## Appeal Decision

**Appeal Ref: APP/T2350/W/19/3239000**

**Three Millstones Inn, Waddington Road, West Bradford BB7 4SX**

- The appeal is made under section 78 of the Town and Country Planning Act 1990 against a refusal to grant planning permission.
  - The appeal is made by Mr Matthew Frost against the decision of Ribble Valley Borough Council.
  - The application Ref 3/2019/0554, dated 14 June 2019, was refused by notice dated 27 September 2019.
  - The development proposed is new single storey building at the rear of the public house to create an additional guest bedroom.
-

SITE PLANS

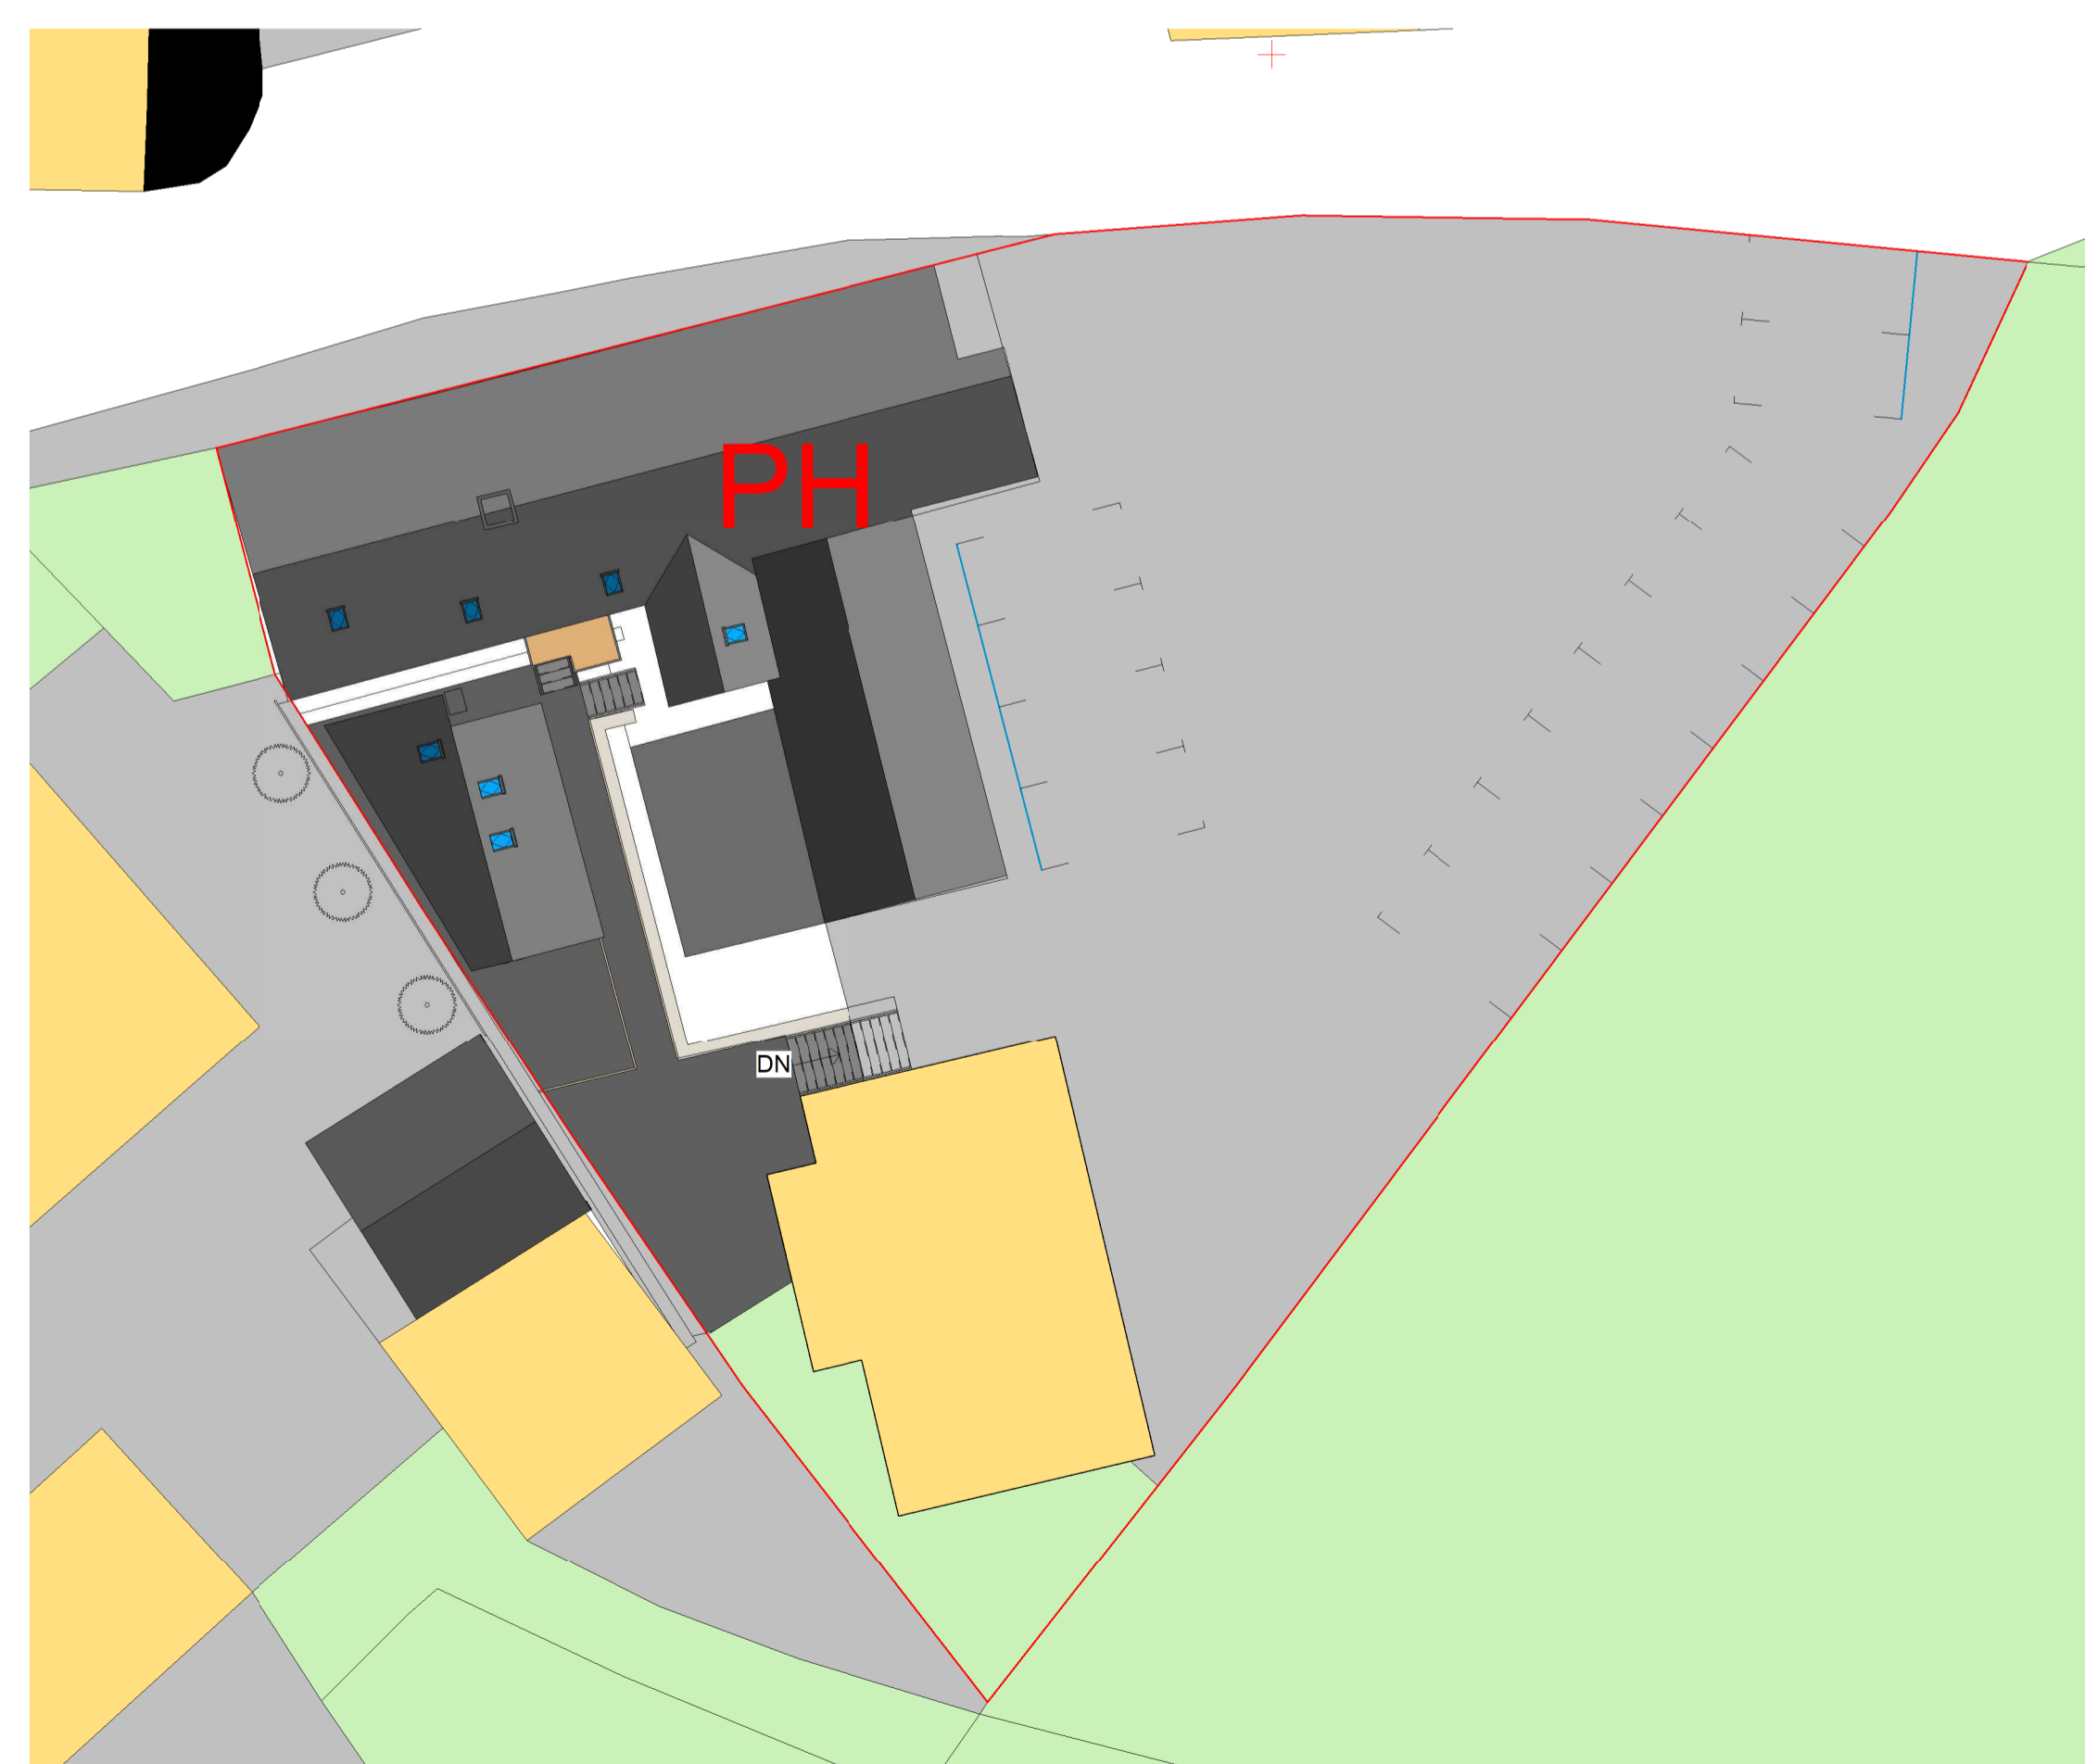
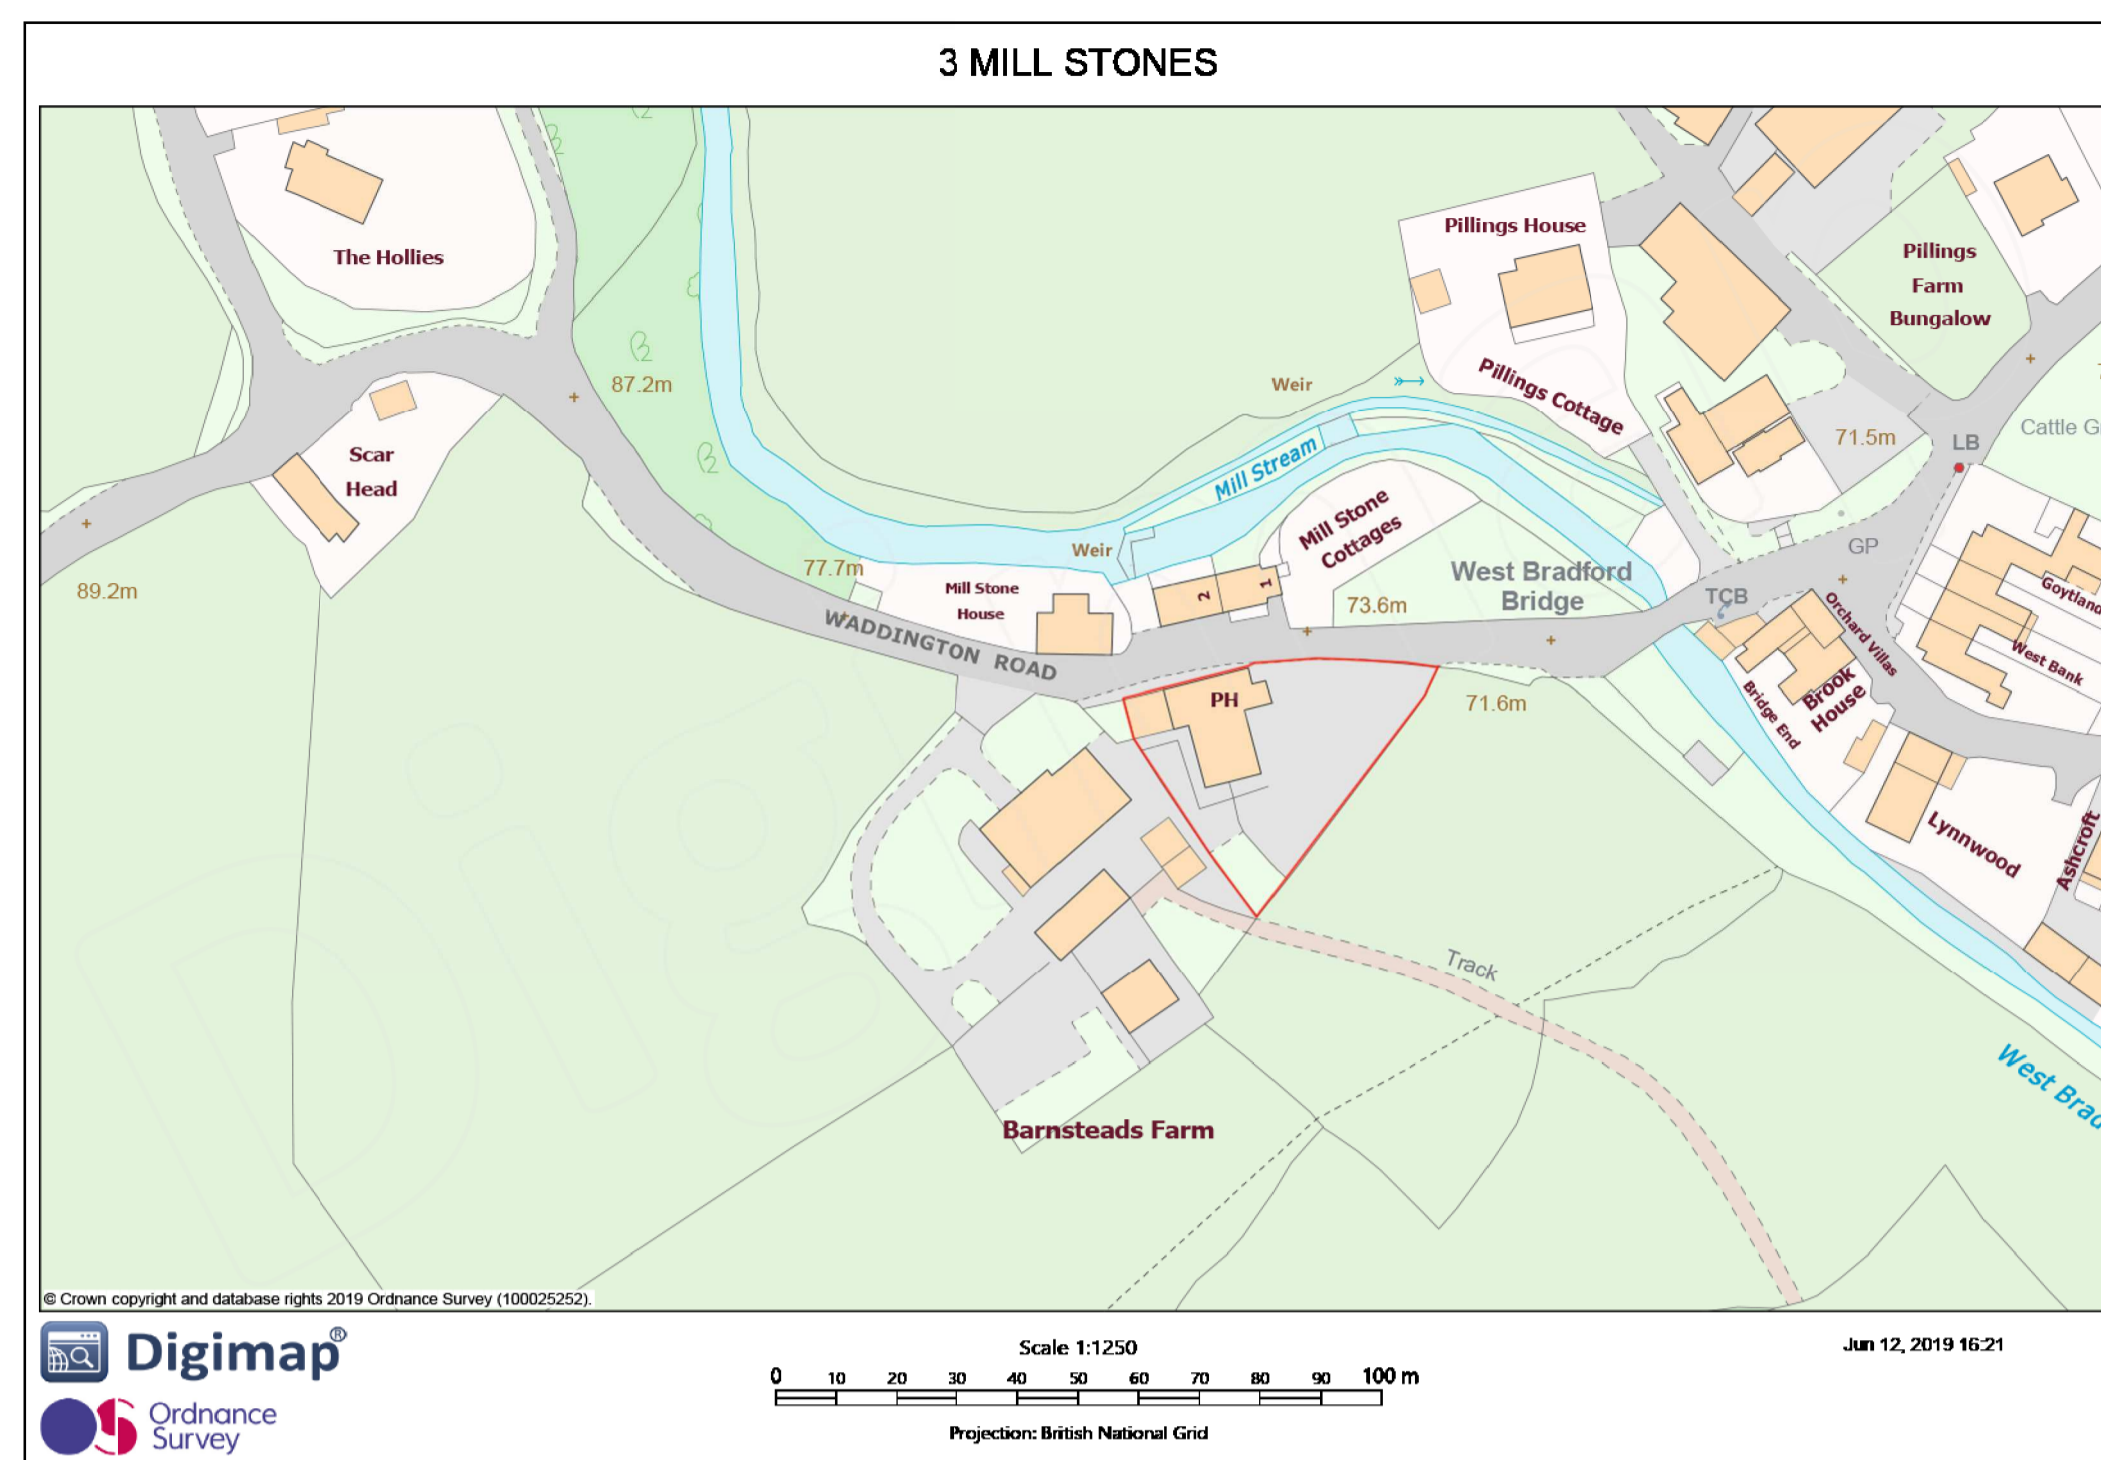
17. The Council has expressed concerns that there is already a shortfall in parking provision within the site. However, the parking area available within the site appears to be the same as that which existed when the Council recently granted planning permission for 5 guest bedrooms within the existing public house building, in addition to the recently-built accommodation building in the rear part of the site.

19. The Council's concerns regarding the width of the access from the site onto Waddington Road appear to have been raised at the time the detached accommodation building in the rear of the site was permitted and, I am advised, there was a condition on that permission requiring the access to be narrowed. It therefore appears that the Council could pursue enforcement action to address those concerns raised in the event that condition has not been complied with. In any event, since the evidence before me does not suggest that circumstances have changed materially in the intervening period, and as the single unit of accommodation now proposed would not materially increase the number of vehicle movements into or out of that access, I consider that the matter could be satisfactorily addressed by means of a similar condition were I to grant permission in this case.
